From: Sarah Burrow <Sarah.Burrow@arun.gov.uk>
Sent: 04 May 2022 11:55
To: Amber Willard <Amber.Willard@arun.gov.uk>
Cc: Planning.Responses <Planning.Responses@arun.gov.uk>
Subject: RE: Planning Consultation on: BN/28/22/DOC

Application No: BN/28/22/DOC

Site Address: Land the rear of Highground House and Orchard End Barnham

Description of Works: Approval of details reserved by condition imposed under BN/114/21/PL relating to conditions 3-schedule of materials and finishes, 4-renewable energy, 6-Construction Management Plan, 8-bin storage, 10-covered and secure cycle parking spaces, 11-electric vehicle charging points, 12-surface water drainage, 14-foul water drainage and 17-external lighting.

DRAWING TITLE
DRAINAGE LAYOUT

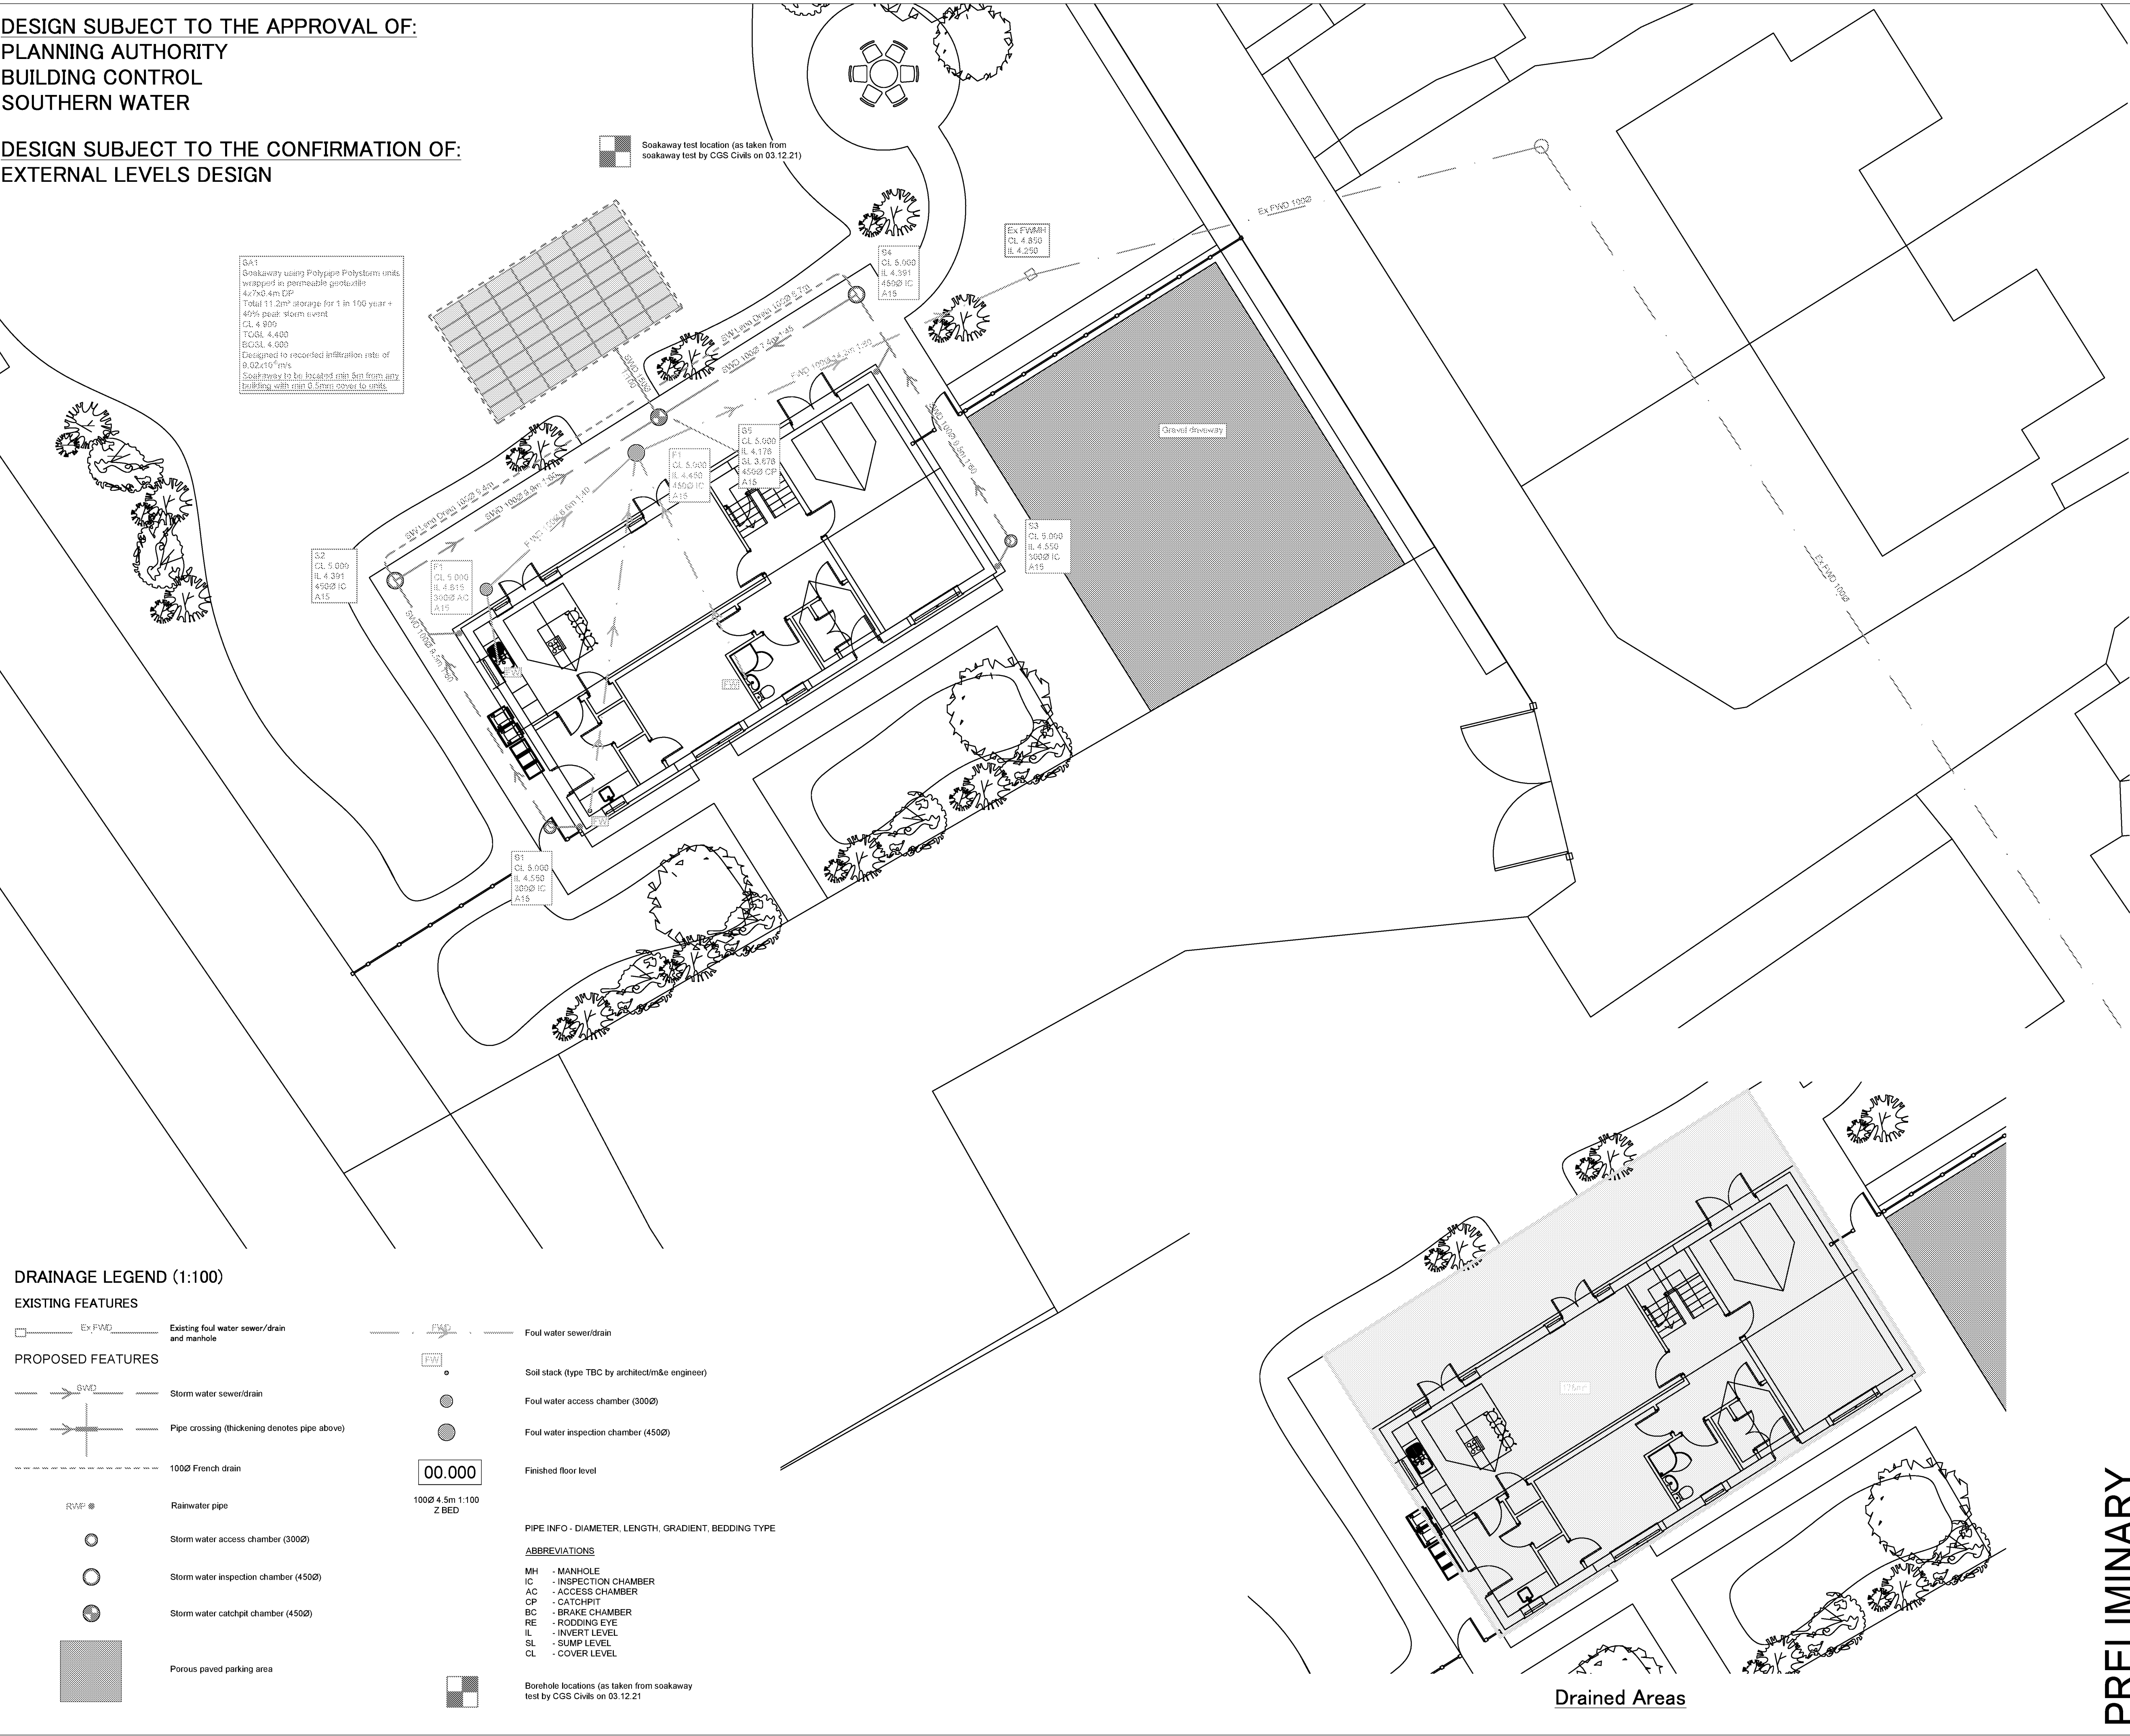
One minor alteration is requested before I recommend discharge of said condition; please can the invert level of the incoming pipe to the soakaway be shown on the drainage layout. At present it could easily be misunderstood to be laid at the base of the soakaway and it needs to be at least 74mm from the base (above the 1 in 10 +40% level).

My apologies, I must've missed the request. The new plan is fine and I recommend that the condition is discharged.

All surface water drainage should be constructed in accordance with the following drawings:

- Drainage Layout C1931 P 100 P1
- Drainage Details C1931 P 200 P- (In surface water drainage report)
